From: Simon Davis
Sent: 11 March 2019 16:51
To: Planning.Responses
Subject: FW: Y/9818/RES and Y/97/18/DOC

Drainage Engineer comments – please add to both applications.

From: Laura Gibbons
Sent: 11 March 2019 16:11
To: Simon Davis <Simon.Davis@arun.gov.uk>
Cc: Mark Warwick <Mark.Warwick@arun.gov.uk>
Subject: RE: Y/9818/RES and Y/97/18/DOC

scheme: Burdell Road
Yapton
client: Bovis Homes (Southern Counties)
drawing: Tree Protection Plan
date: November 2018
scale: 1:500@A1
dwg no: BOV22172-03C
drawn: MW checked: TRG

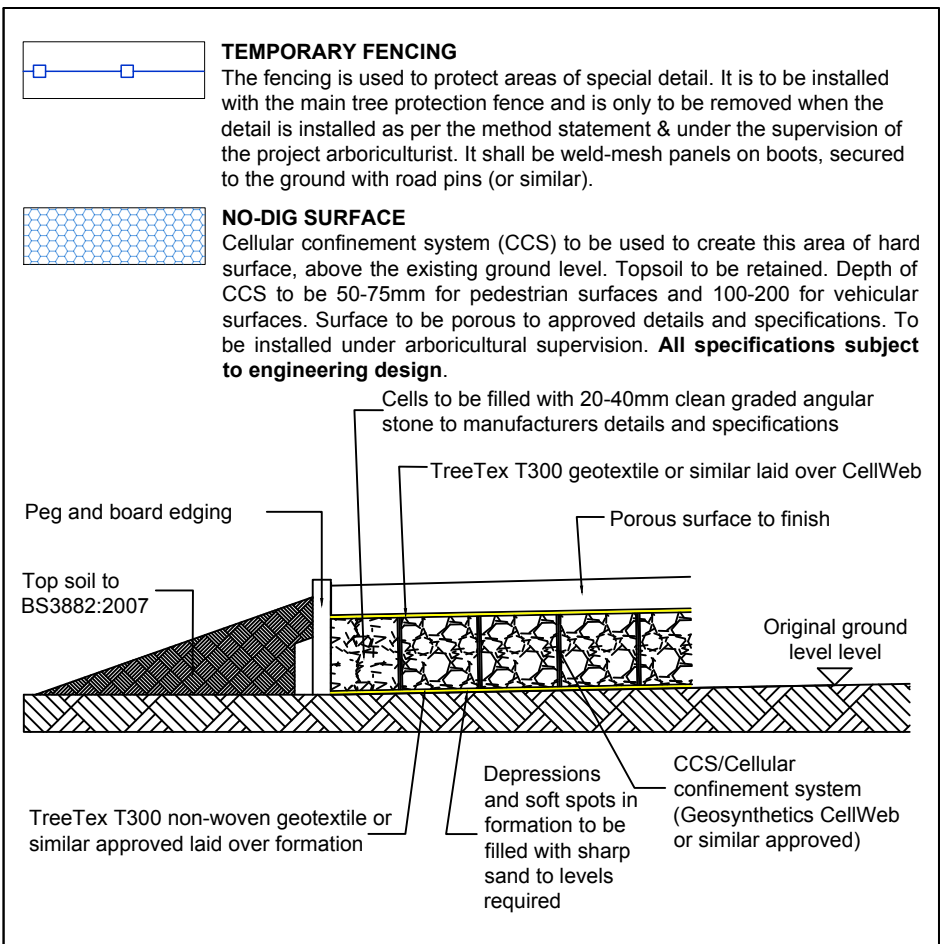
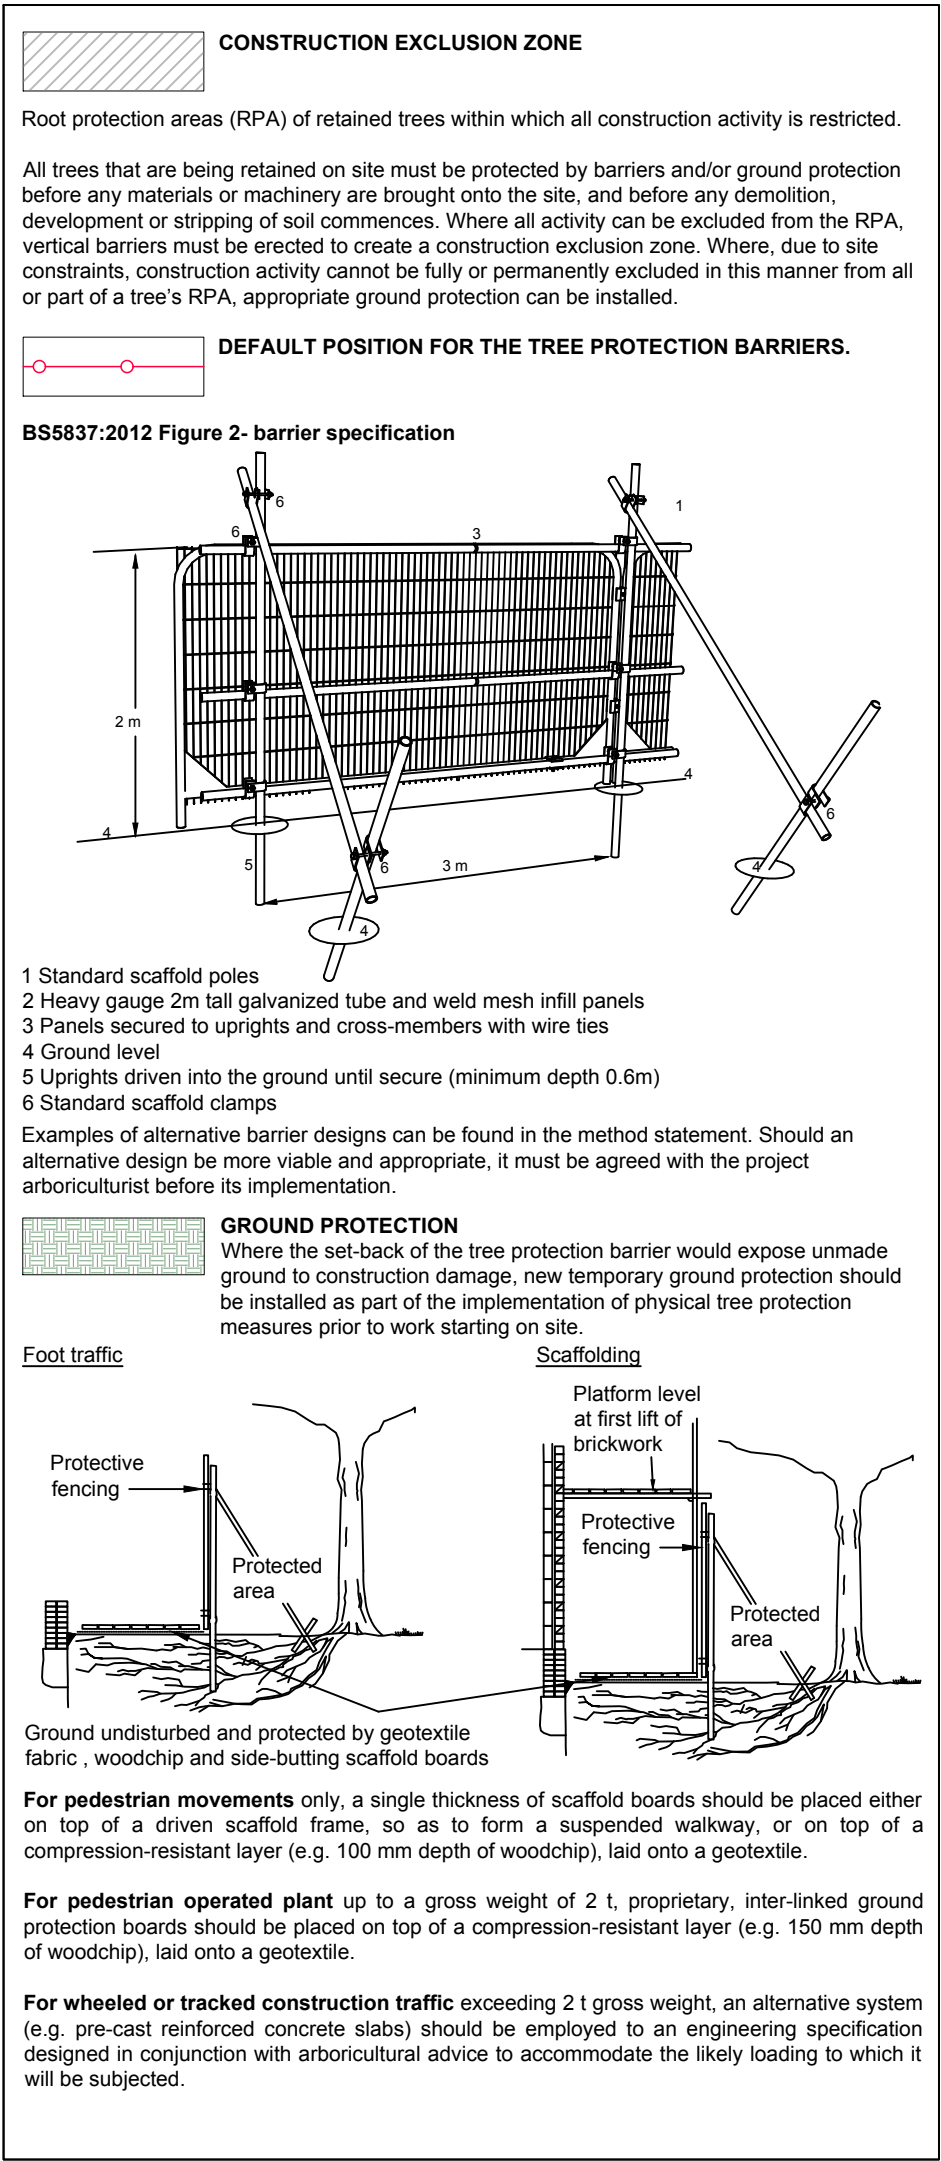
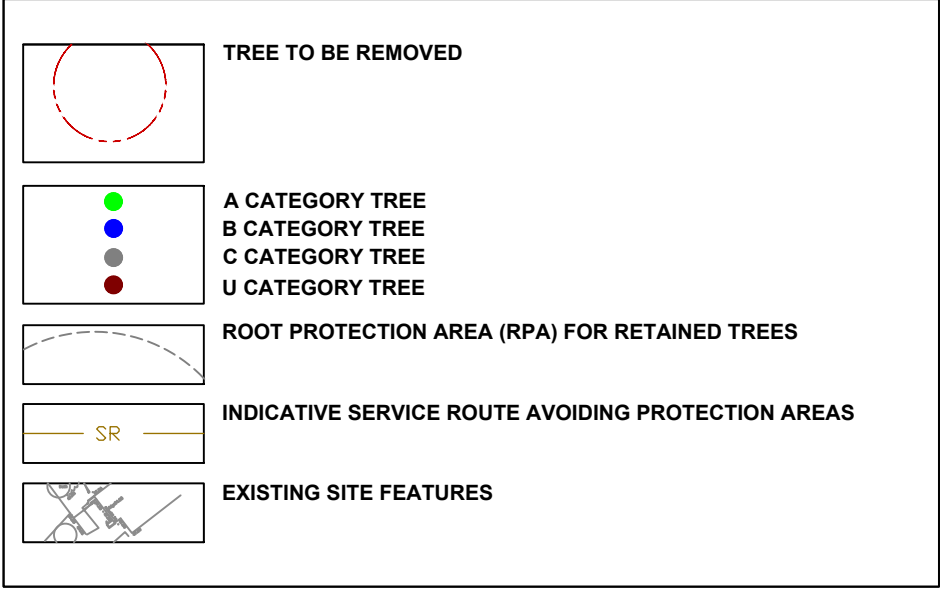
There are still trees located in close proximity and in some instances over the attenuation tanks. These need to be removed. Attenuation tanks must not conflict with potential root areas of proposed trees.
